**WELWYN HATFIELD BOROUGH COUNCIL  
EXECUTIVE DIRECTOR - PLANNING, PUBLIC PROTECTION AND GOVERNANCE**

**DELEGATED APPLICATION**

**Application No:** 6/2022/2526/PN27  
**Location:** Postern Gate Farm Newgate Street Village Hertford SG13 8QR  
**Proposal:** Prior approval for the construction of an additional storey to facilitate the enlargement of the dwellinghouse to a maximum of approximately 2.8m in height following the demolition of existing roof  
**Officer:** Ms Elizabeth Mugova

[02] SITE PLAN 1:200

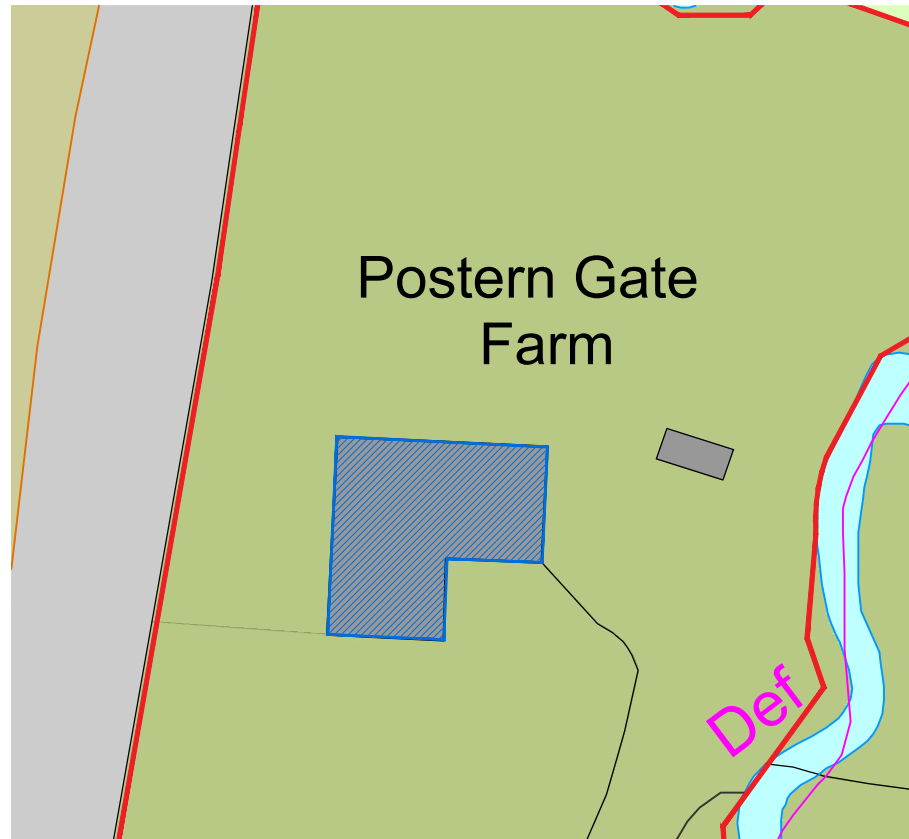
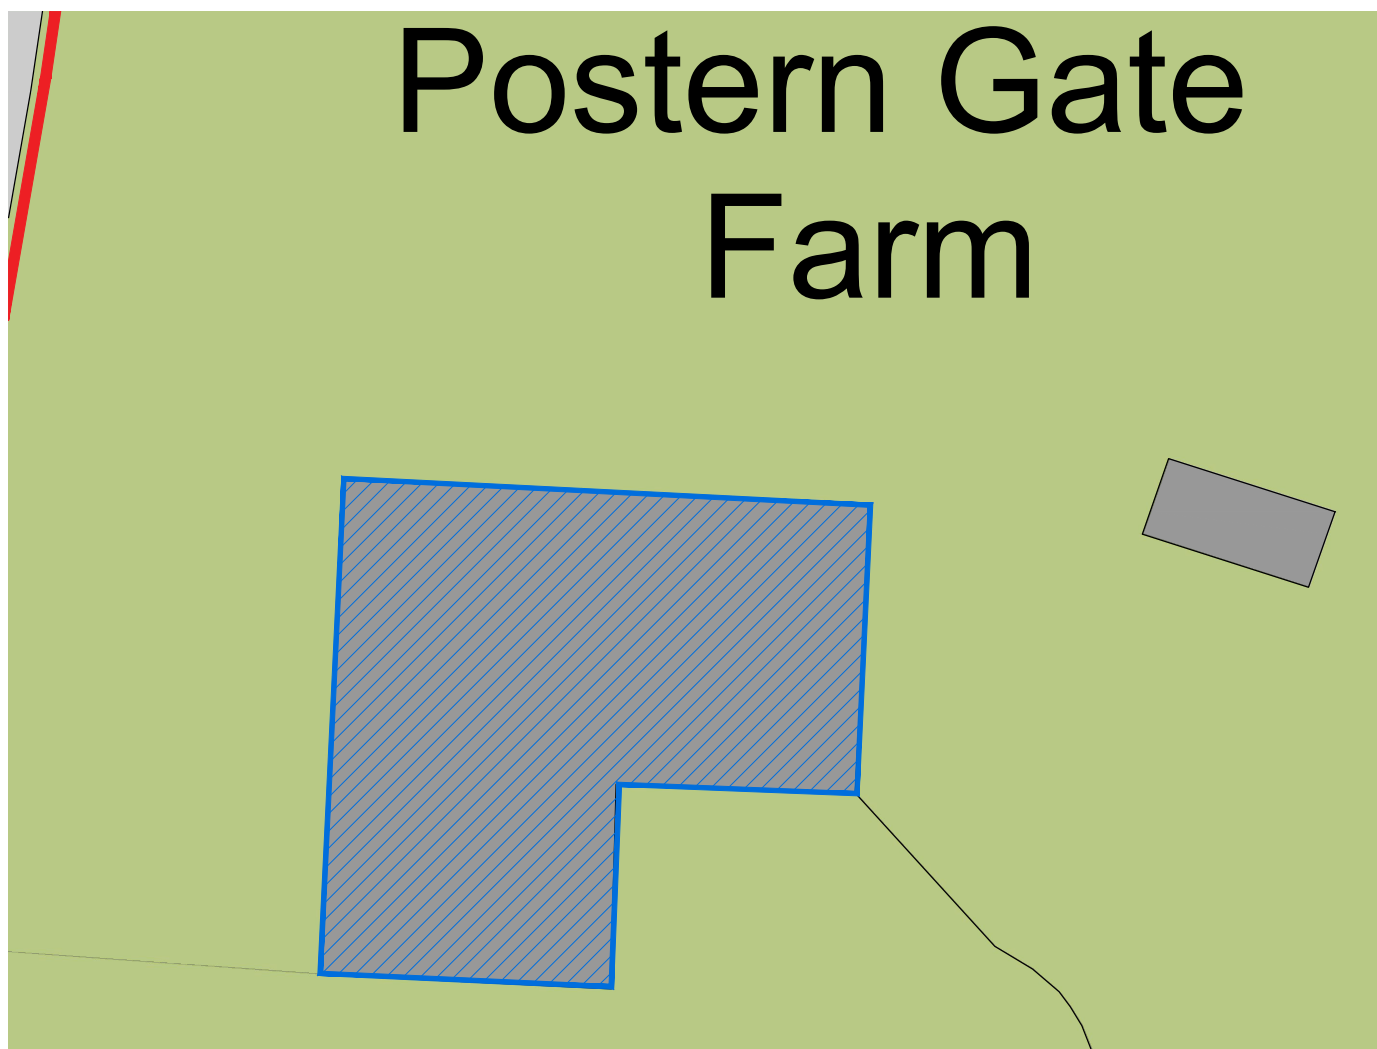
- A comment has been made highlighting that the railway line is not shown on the site plan. The railway line is shown on the 'Existing Location and Site Plan, Drawing No. 292\_E01.
